CITY OF ALBUQUERQUE

OFFICIAL NOTIFICATION OF DECISION

Project# 1005354
16EPC-40059 Amend Site Development Plan for
Building Permit
16EPC 40060 Amend Site Development Plan for
Subdivision

CONDITIONS OF APPROVAL: 16EPC-40059, Site Development Plan for Building Permit:

V.3  
SDP 1.1  
SHEET 1 OF 1

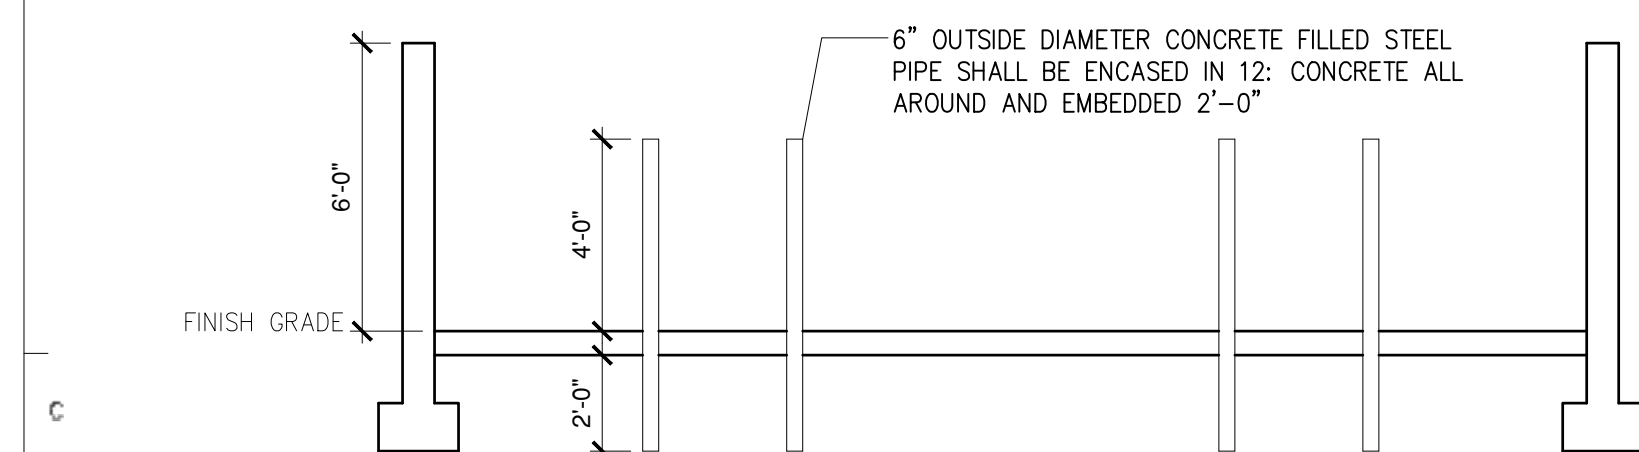
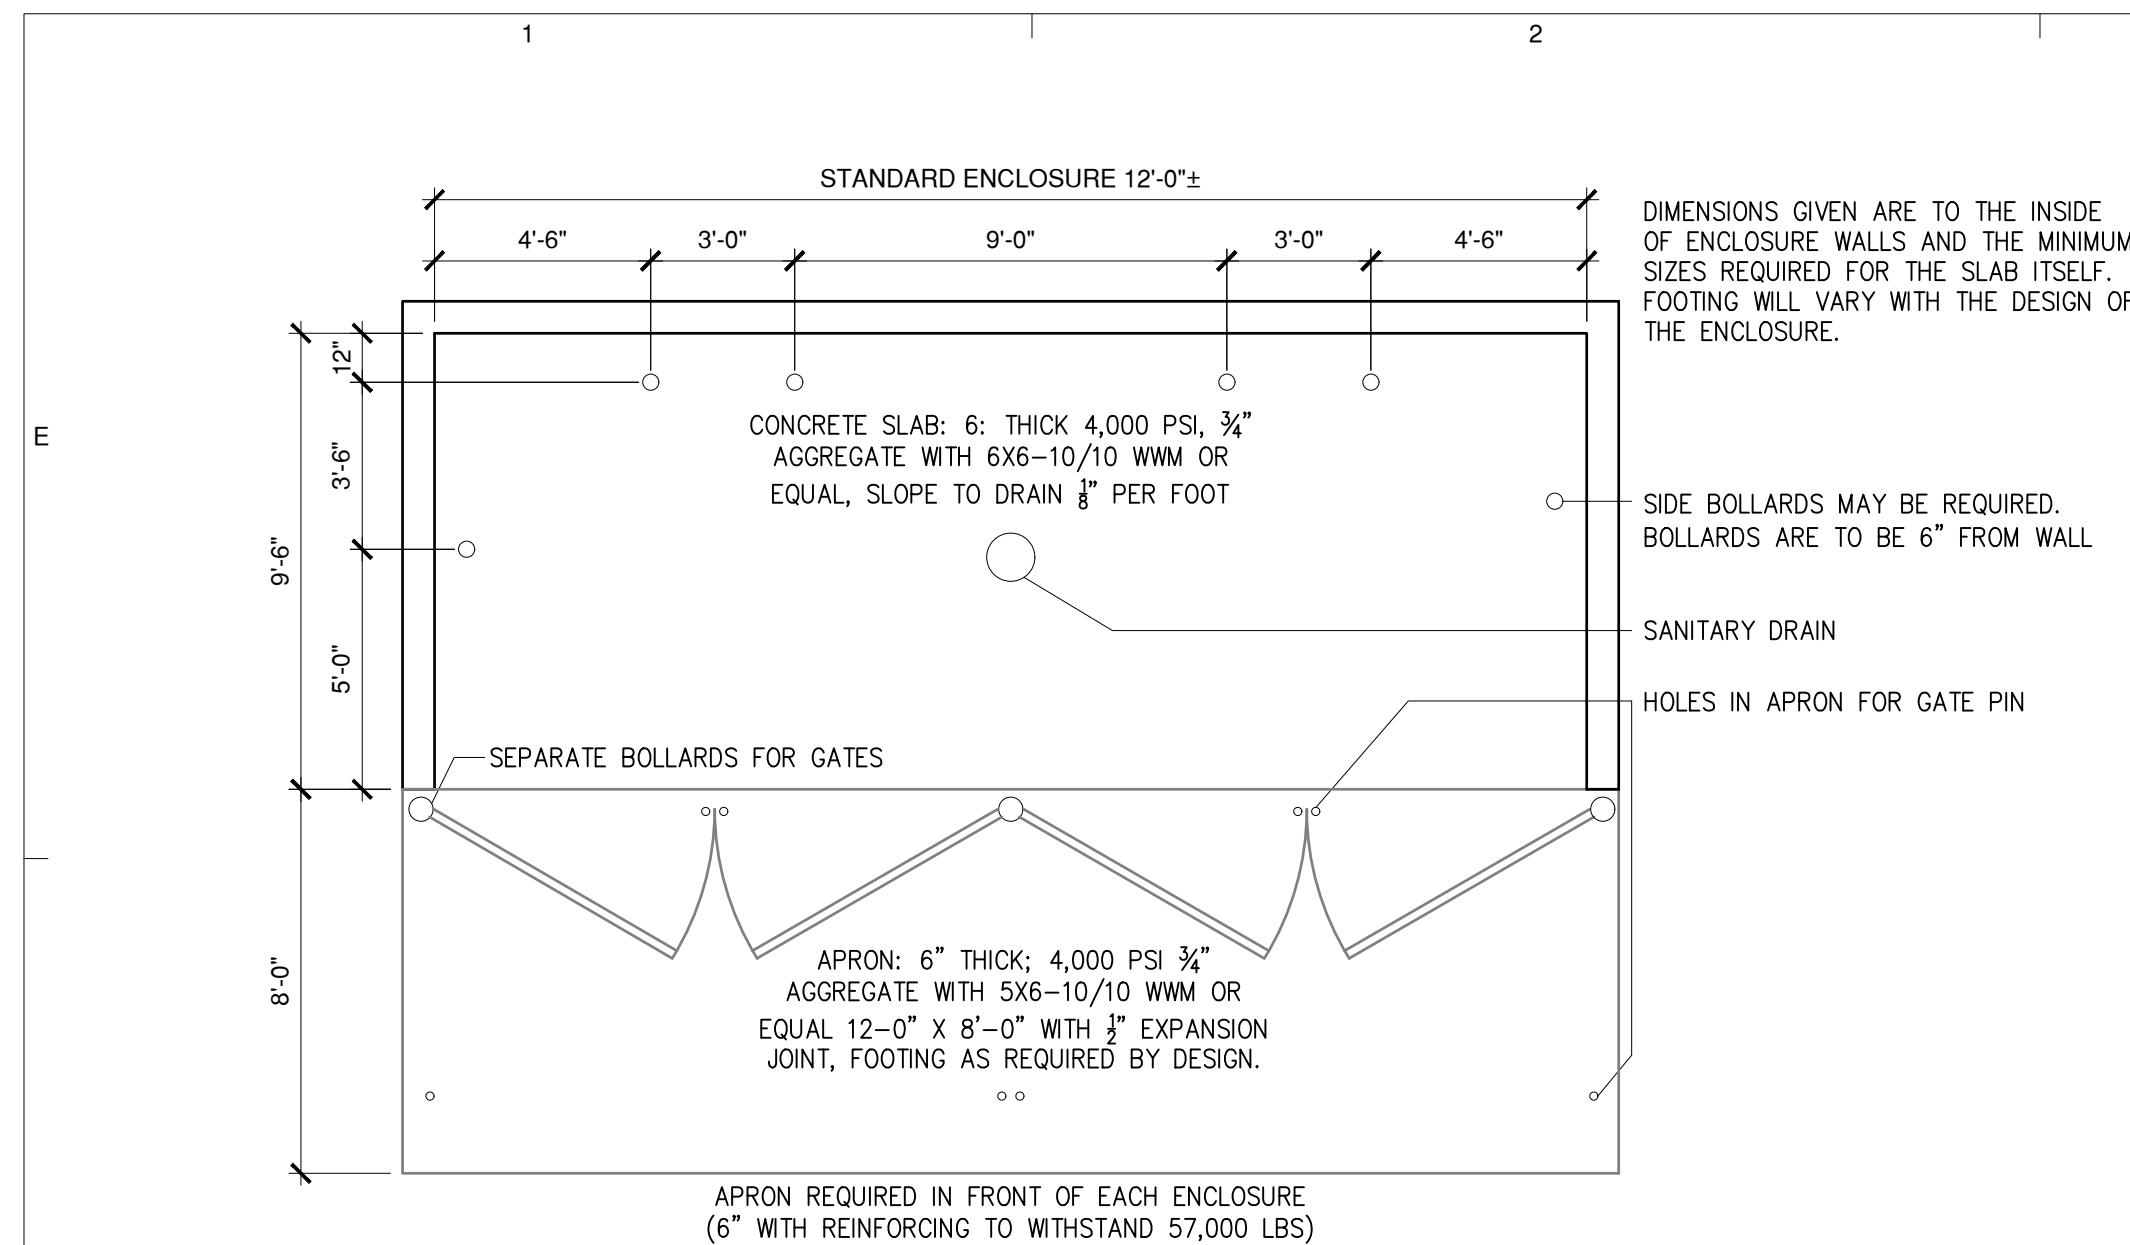
- B. Parking space totals shall be indicated by summary numbers (Sheet SDP 1.1).
 - C. The location of the motorcycle spaces shall be shown (Sheet SDP 1.0).

LANDSCAPE PLAN

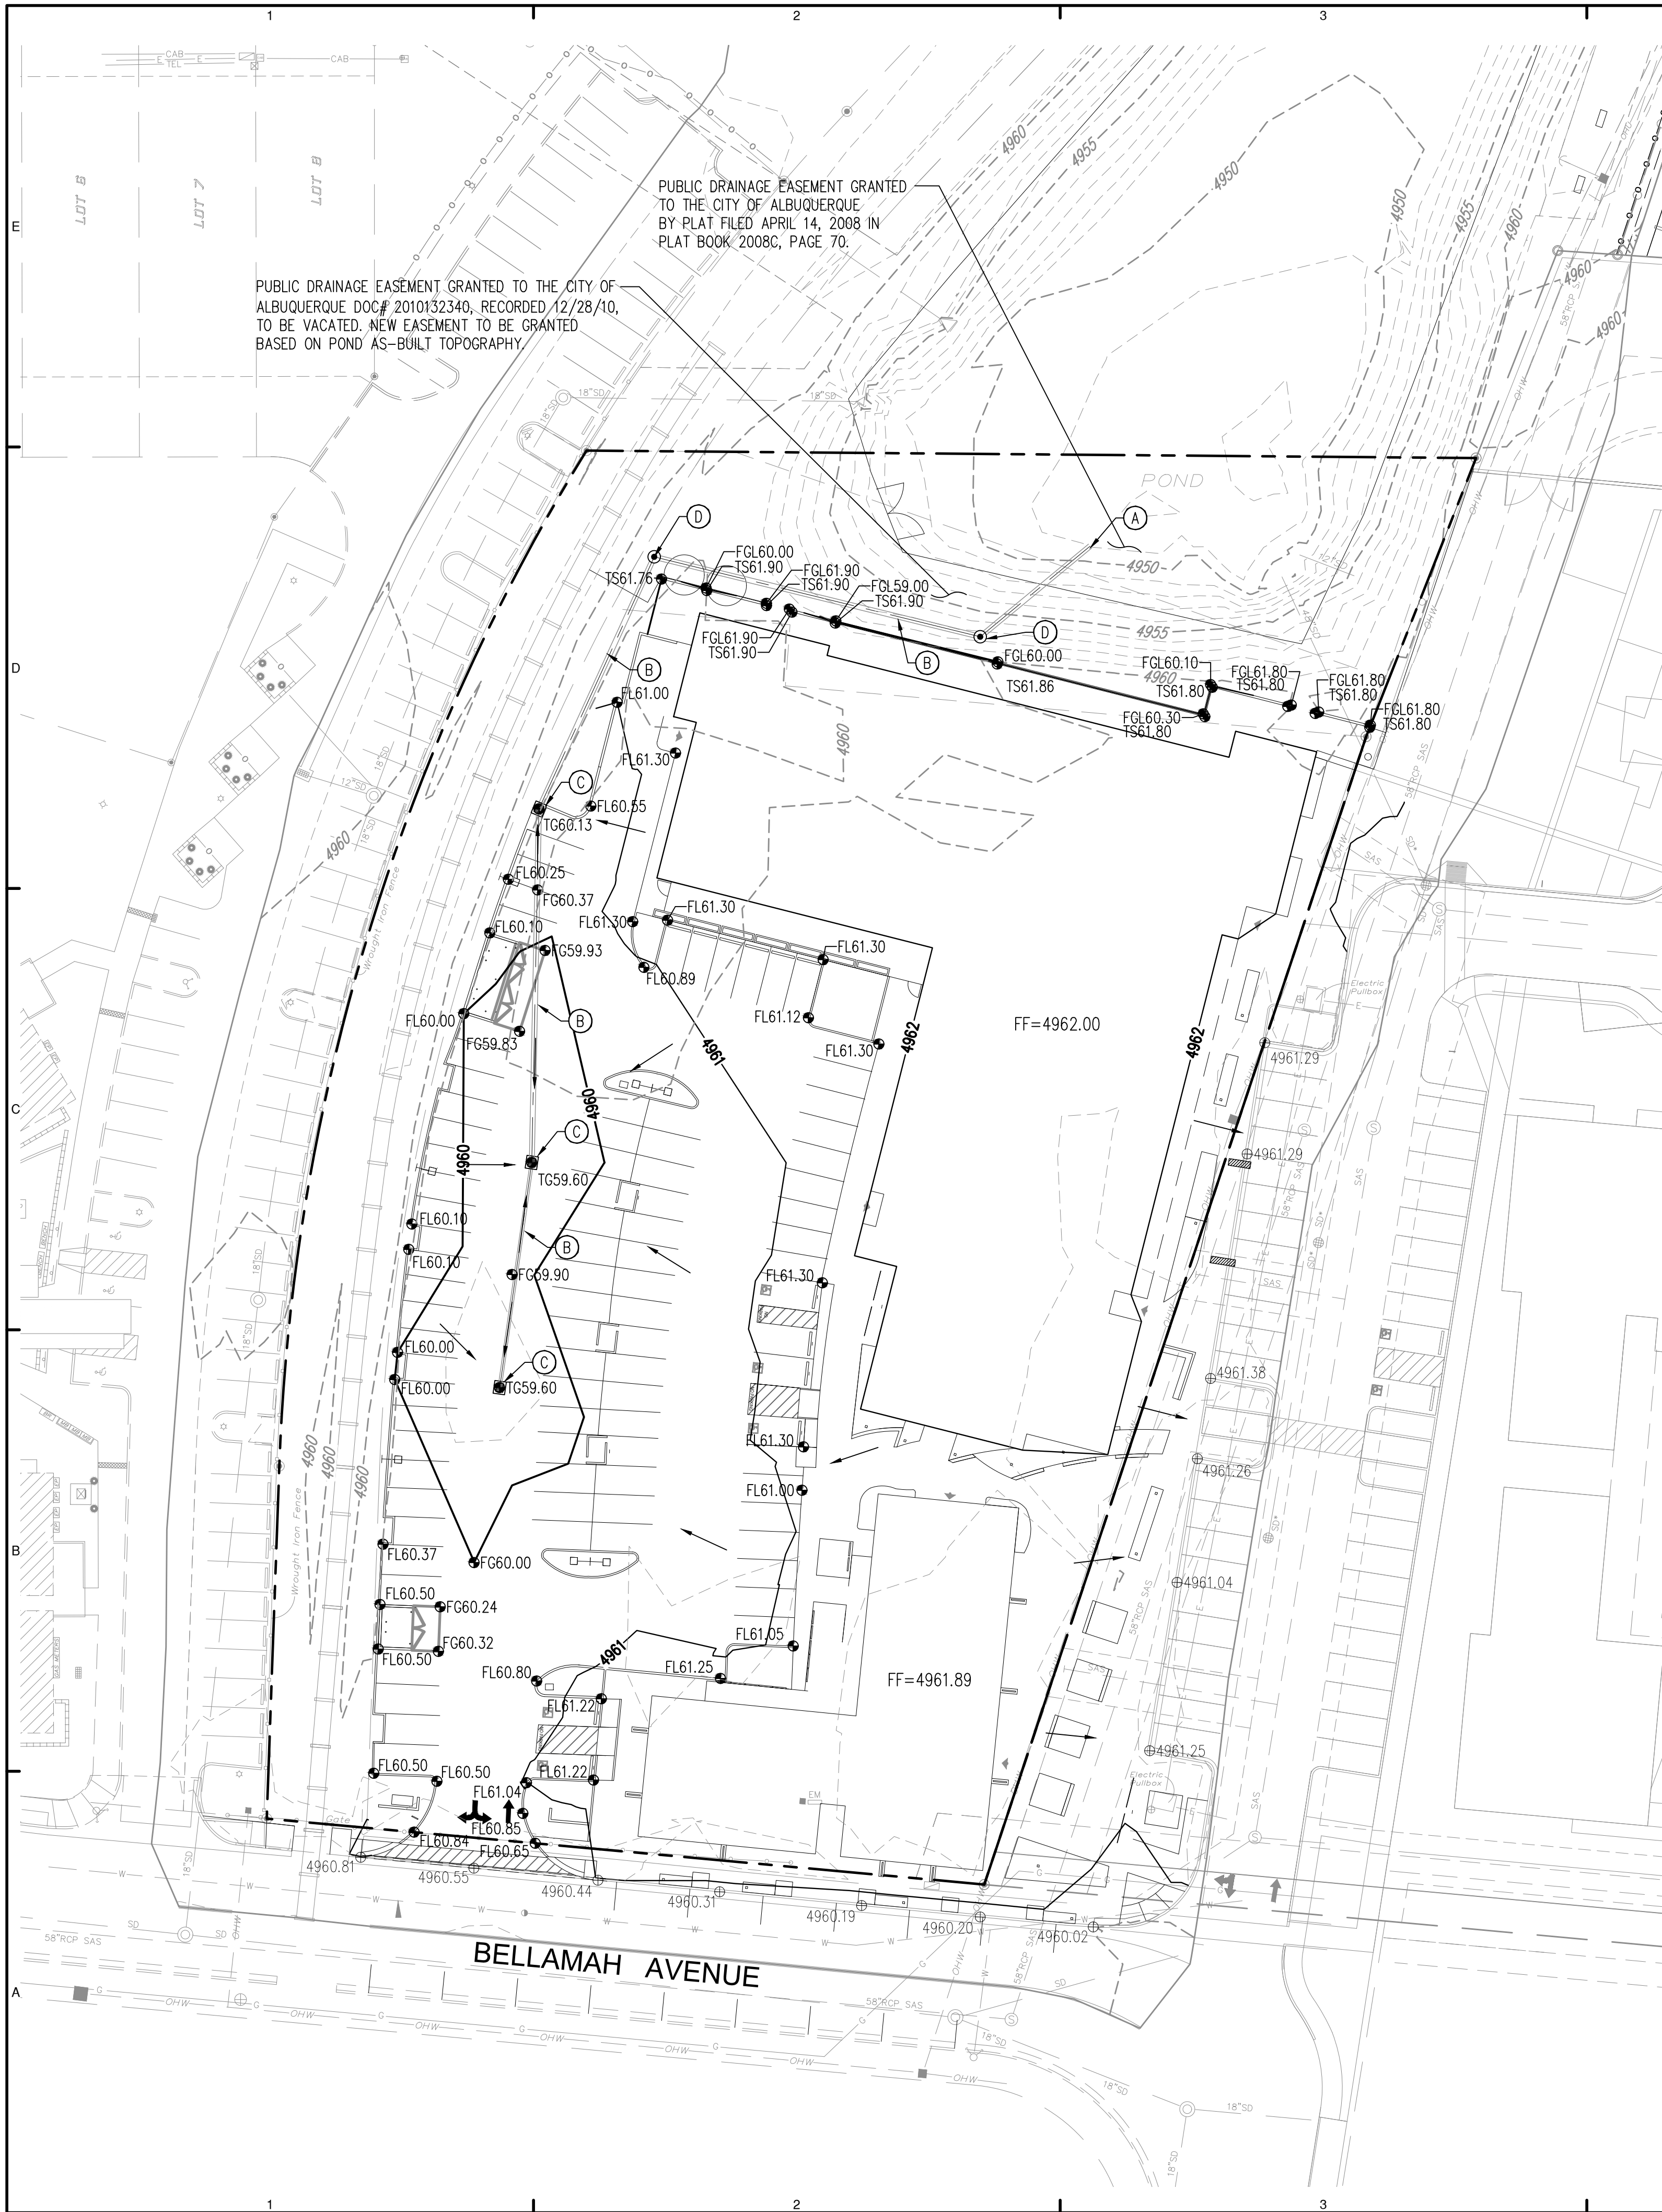
6. Landscaping:
 - A. One of the two additional trees (the northernmost one) approved with the 2011 landscaping plan, along the western boundary of Phase II, shall be included with the current landscaping plan.
